From: Jean Fraser
To: DSenus@woodardcurran.com; Errico Thomas <Thomas.Errico@tylin.com>; Mar...
CC: Barhydt, Barbara; Bourke, Jeanie; Gautreau, Keith; Machado, Ann
Date: 2/12/2016 2:15 PM
Subject: Add'l info re 88 Preble Street (2016-016)ting

Additional info from meeting 2.11.16:

**FLOOR PLAN**  
 SCALE: 3/16" = 1'-0"

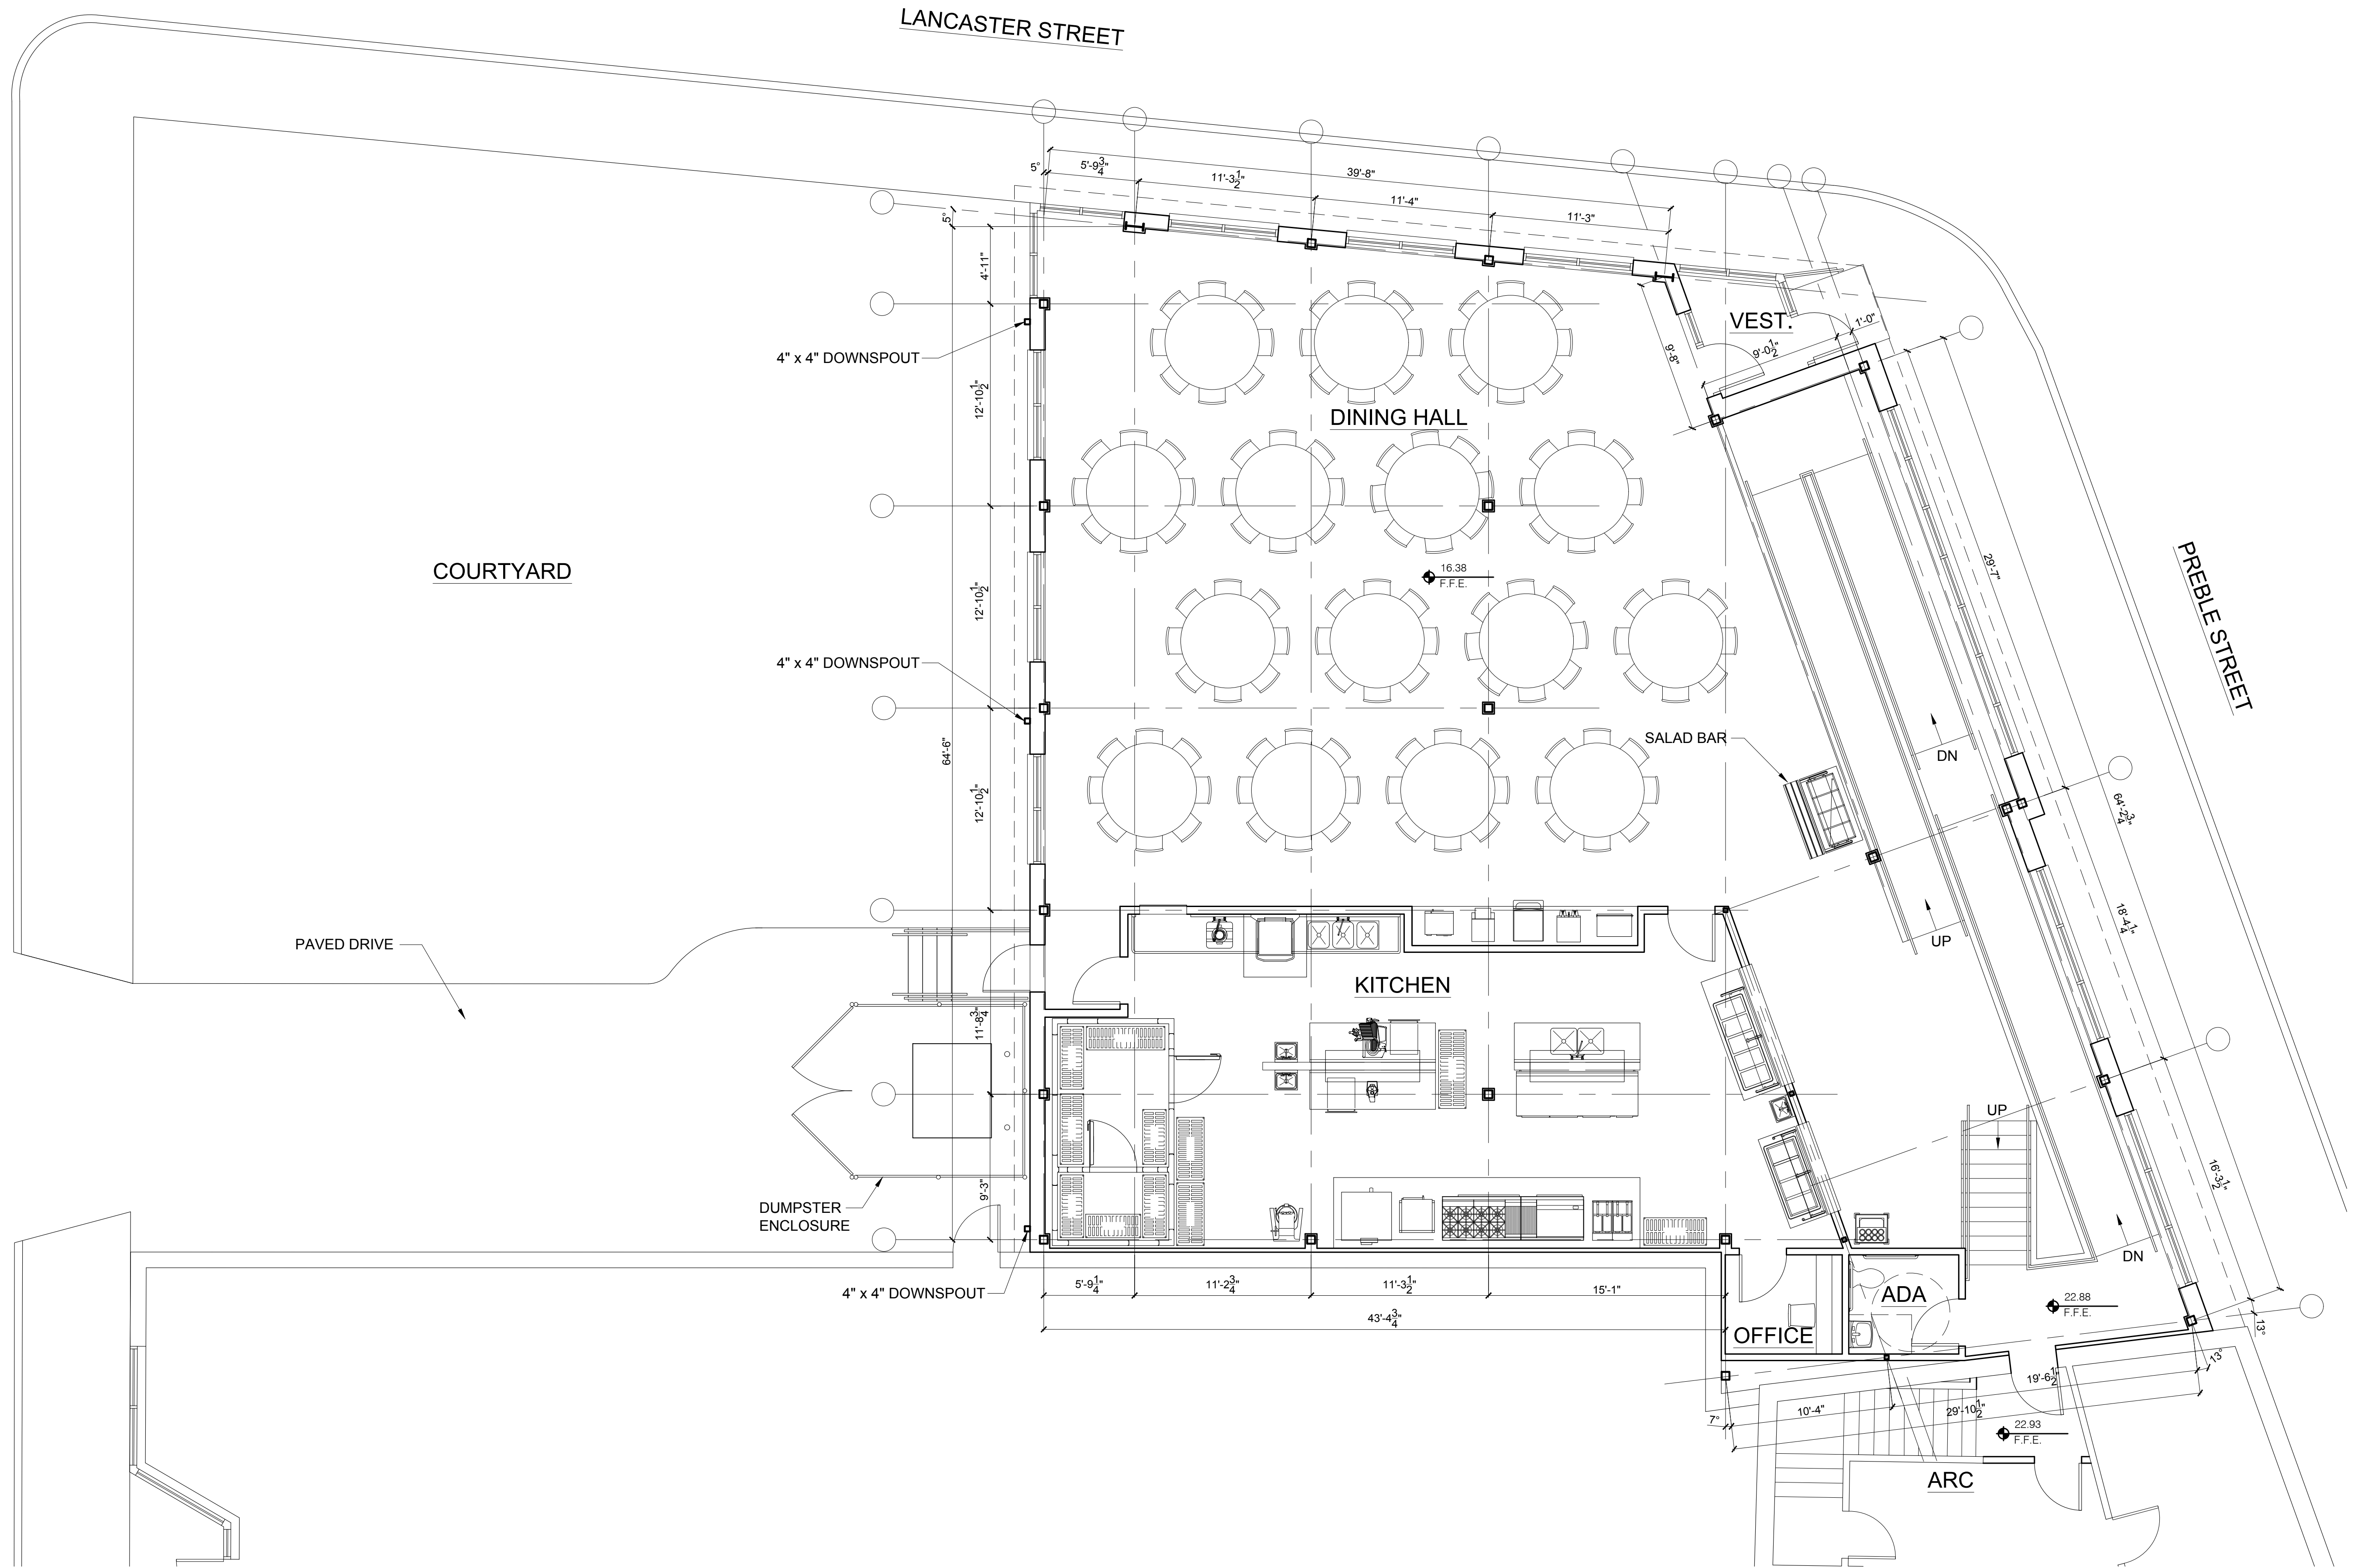
2. **3-ft separation between existing abutting building and proposed building:** (1.75 ft between boundary and existing building; 1.3 ft between boundary and new building)

Fire Department- Fire Prevention: Assistant Chief Keith Gautreau OK re access but needs to check re life safety for occupants of the abutting res. building (fire needs 10 ft separation to make a second floor rescue but its not known if second floor rooms are bedrooms that need egress).

Building Code: Jeanie Bourke OK with it as materials are fire rated and no windows though easement for construction appears to be needed.

Roof and snow loading/shedding: Roof is virtually flat and they can add edge pieces to stop snow from falling onto abutters property

DRAWN BY
SWC
SHEET TITLE
Off-Street Parking Plan

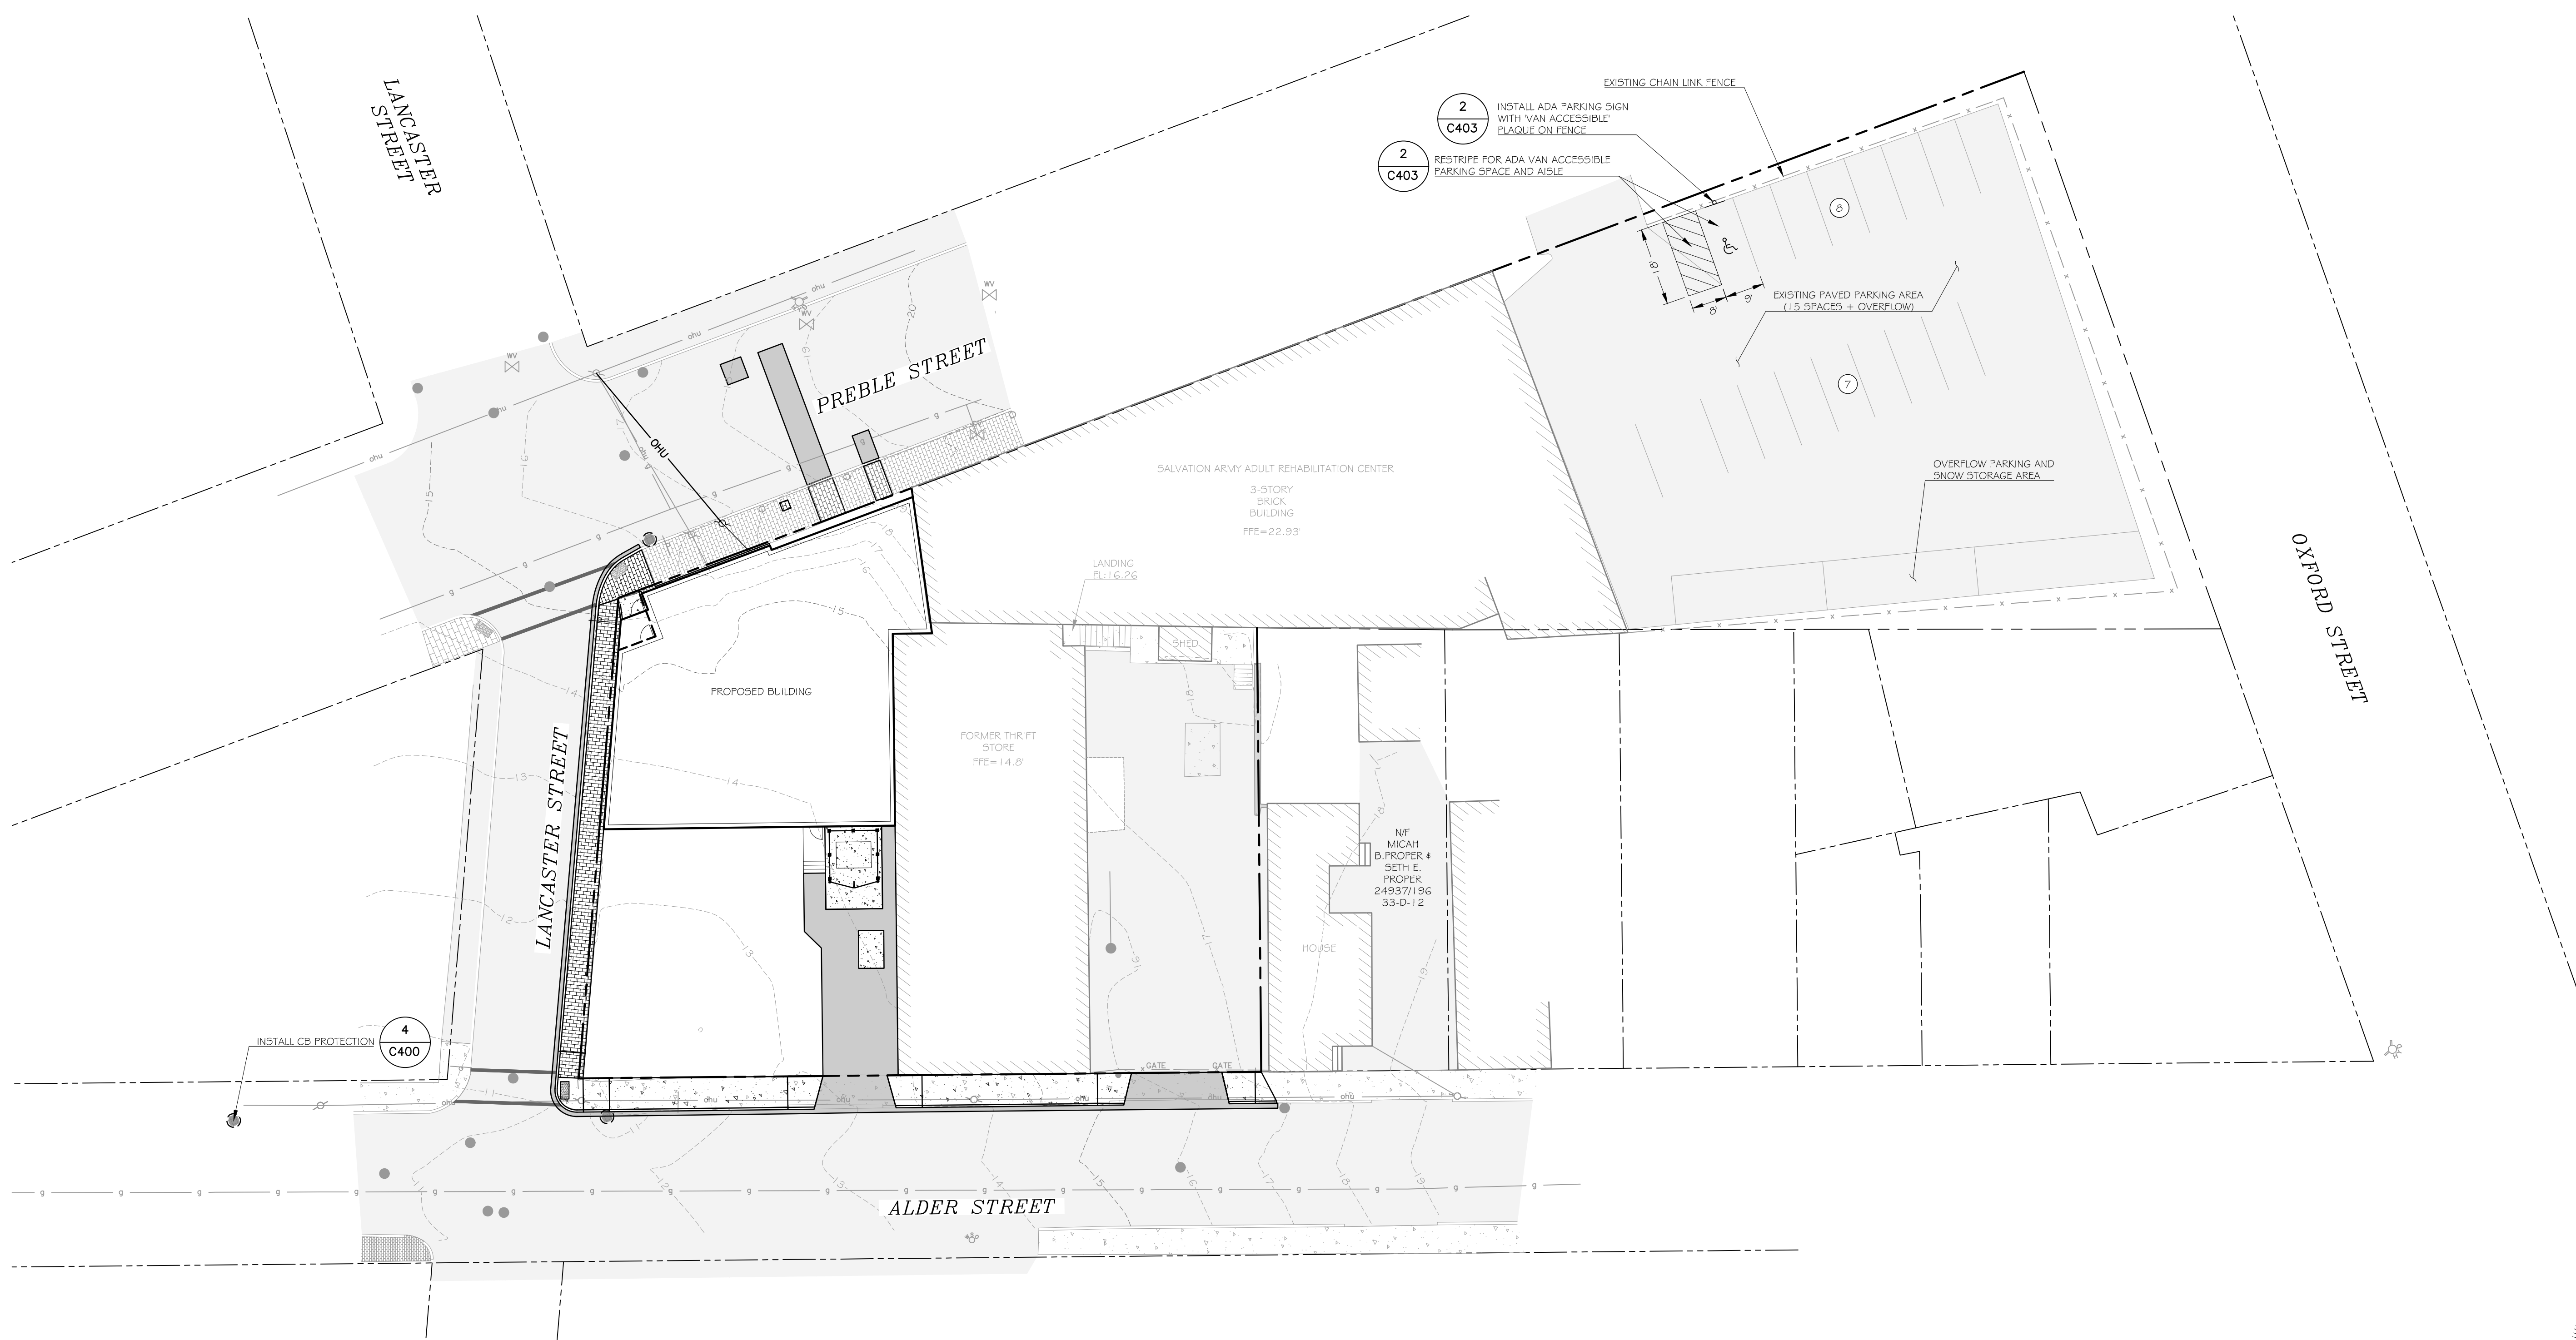
Ann and I are working on the parking requirement, but it looks like it would be in the region of 15 and they have 29 spaces on site. I have advised them that we would want to see some screening of the parking lot to north (treeplanting?) but would not request a wholesale makeover.
